WEST SUSSEX COUNTY COUNCIL CONSULTATION

TO:	Arun District Council FAO:Ms M Tomalova
FROM:	WSCC - Highways Authority
DATE:	8 June 2020
LOCATION:	74 London Road Bognor Regis PO21 1DD
SUBJECT:	BR/108/20/PL Construction of 1 No. new second floor 2 bedroom flat over existing two storey building, additional bedroom to first floor flat, division of ground floor retail unit into 2 No units & change of use of ground floor retail space to form new access to second floor flat. This application may affect the setting of a listed building.
DATE OF SITE VISIT:	n/a
RECOMMENDATION:	Advice
S106 CONTRIBUTION TOTAL:	n/a

PROJECT	London Road	DATE	12/05/20
TITLE	Proposed Plans	DRG NO	IBA/532/03
SCALE	1 : 100	REVISIONS	A

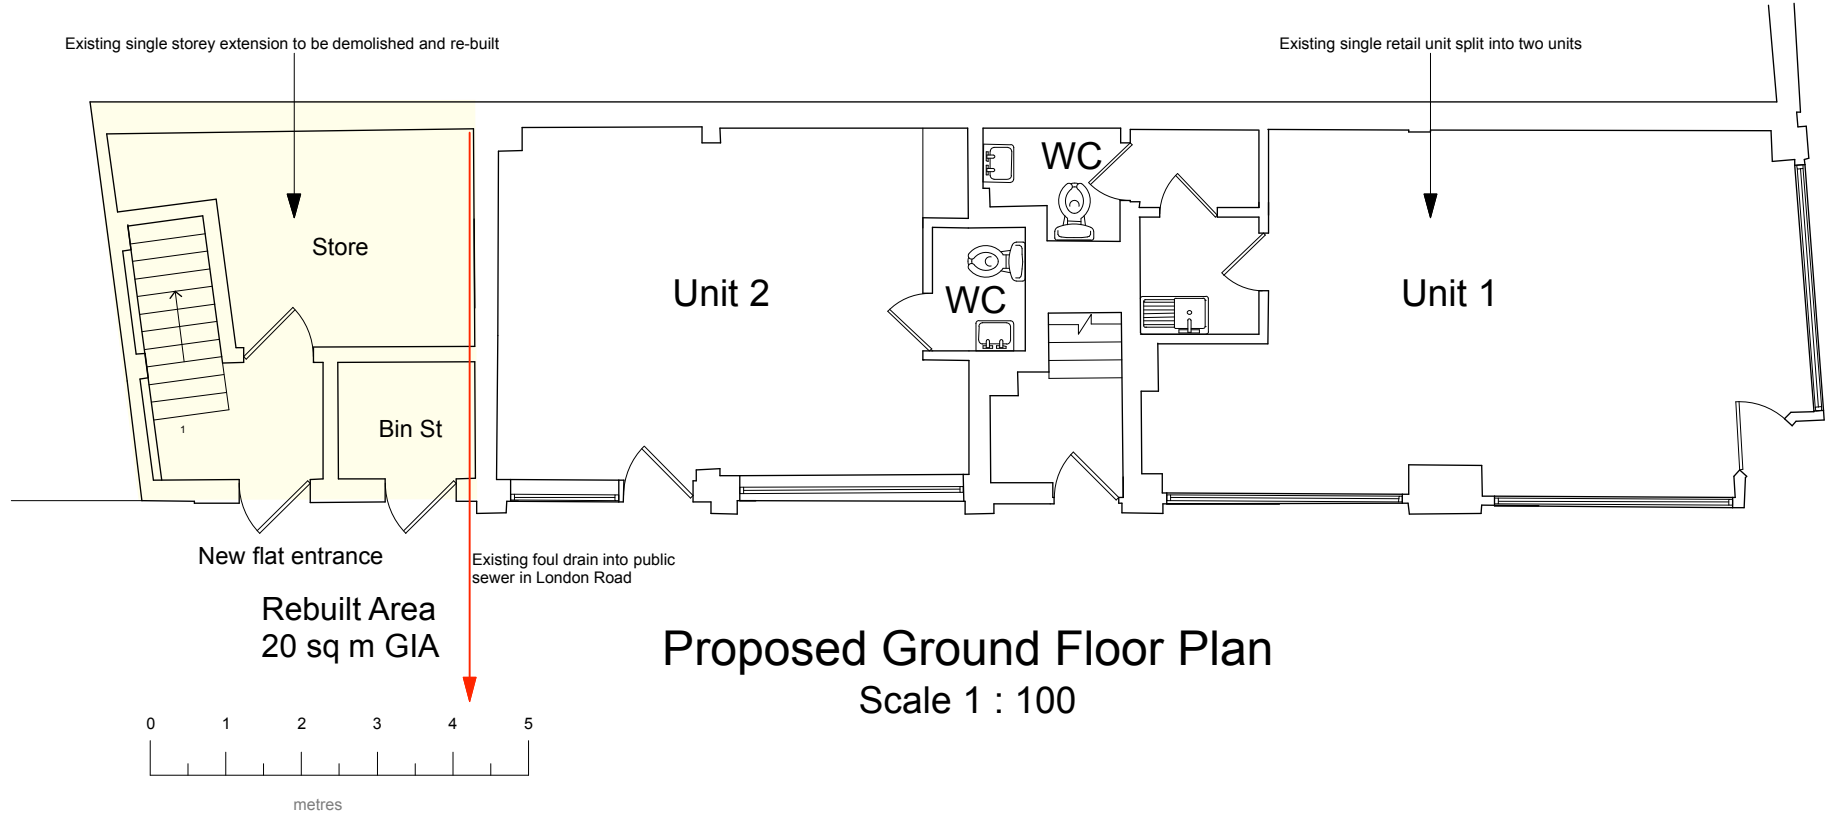
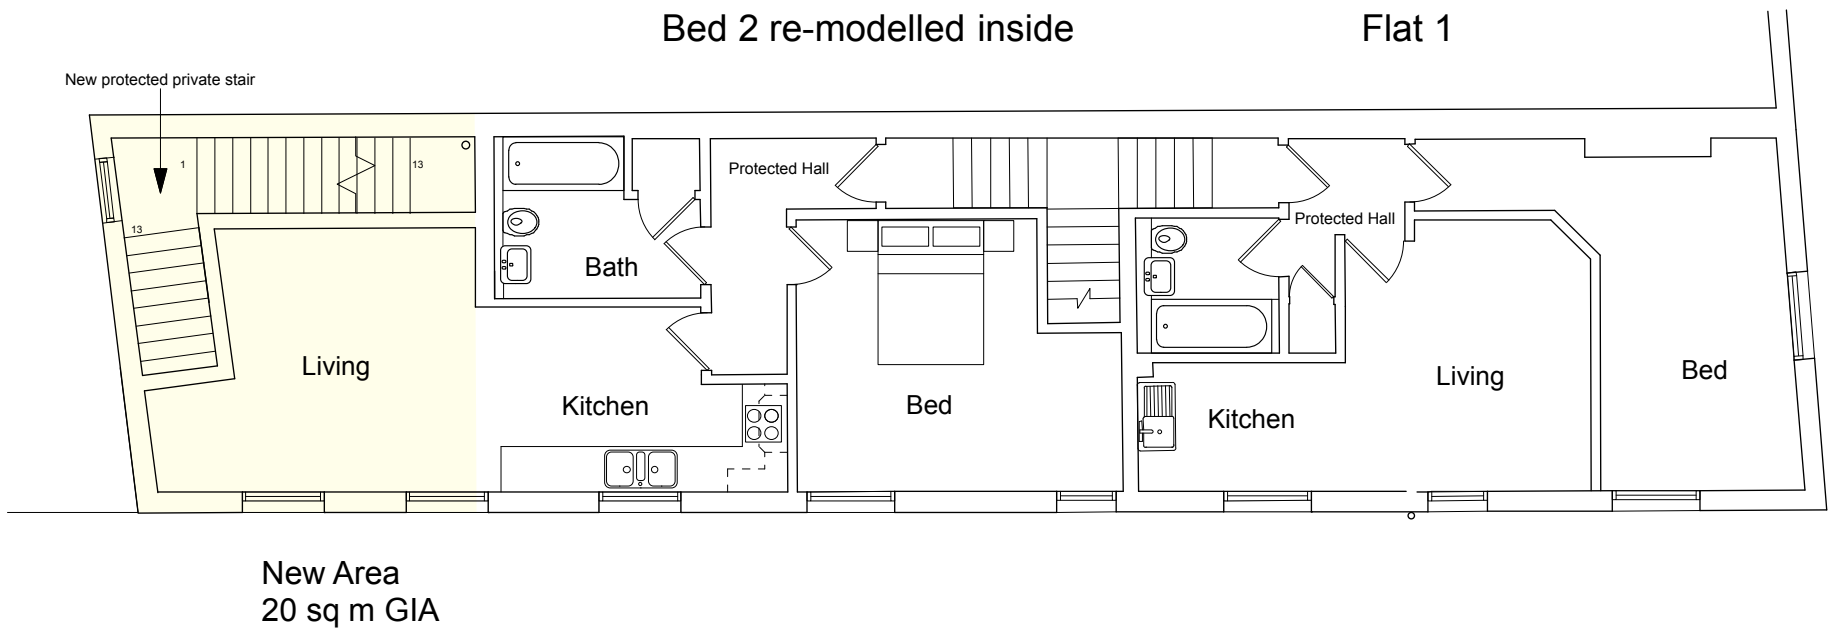
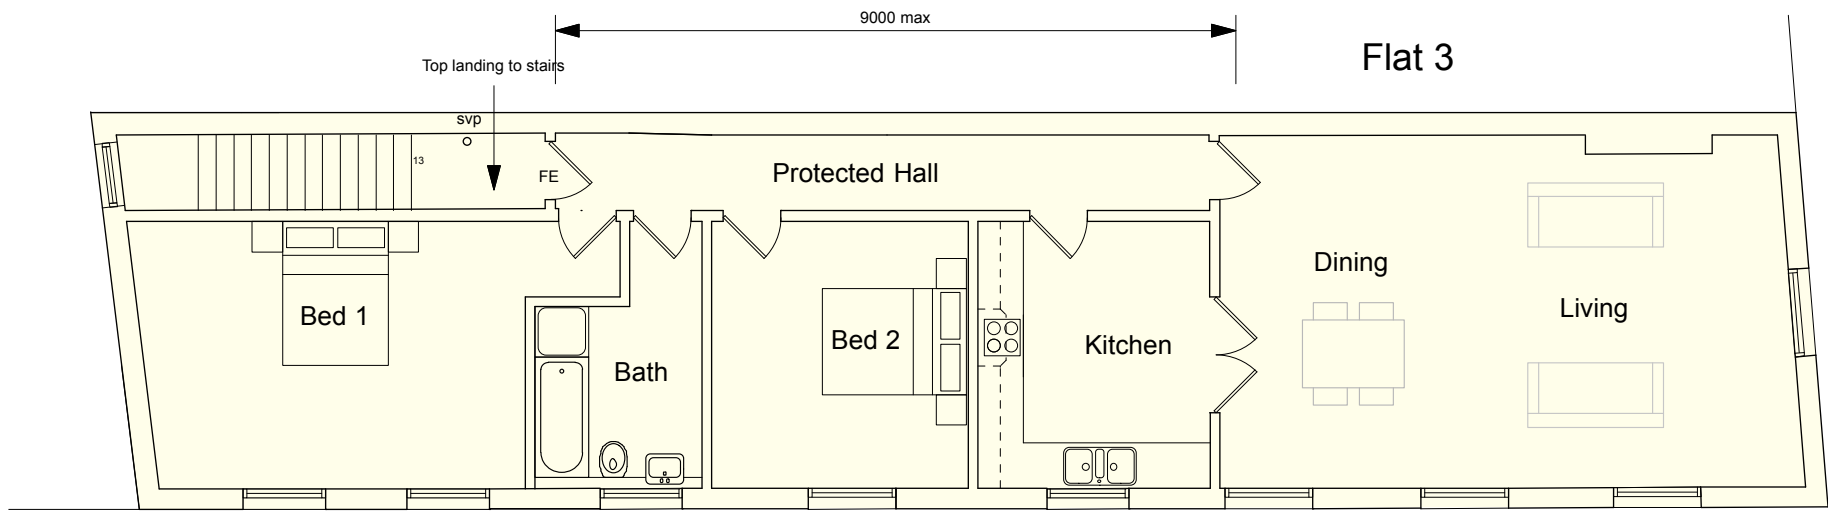
A nil car parking provision is proposed for the new flat. Under the WSCC Car Parking Guidance (adopted August 2019), 2 car parking spaces may be provided for the new flat across the second

floor. No additional parking provision is required for the proposed studio flat conversion to 1 bedroom flat. It is unclear if the new floor space of 140sqm was previously used for storage; therefore some parking provision may be required.

The site benefits from being situated in a sustainable location in a close proximity to local shops and amenities. Bognor Regis train station is approximately 1 min walk. An alternative transport mode to public transport that can be used is cycling. It may be possible to provide a cycle parking facility on site, if so it would be advised that such a provision is secured via planning condition. A suitably worded condition is included below if the Local Planning Authority considers cycle parking achievable.

No part of the development shall be first occupied until covered and secure cycle parking spaces have been provided in accordance with plans and details to be submitted to and approved by the Local Planning Authority.
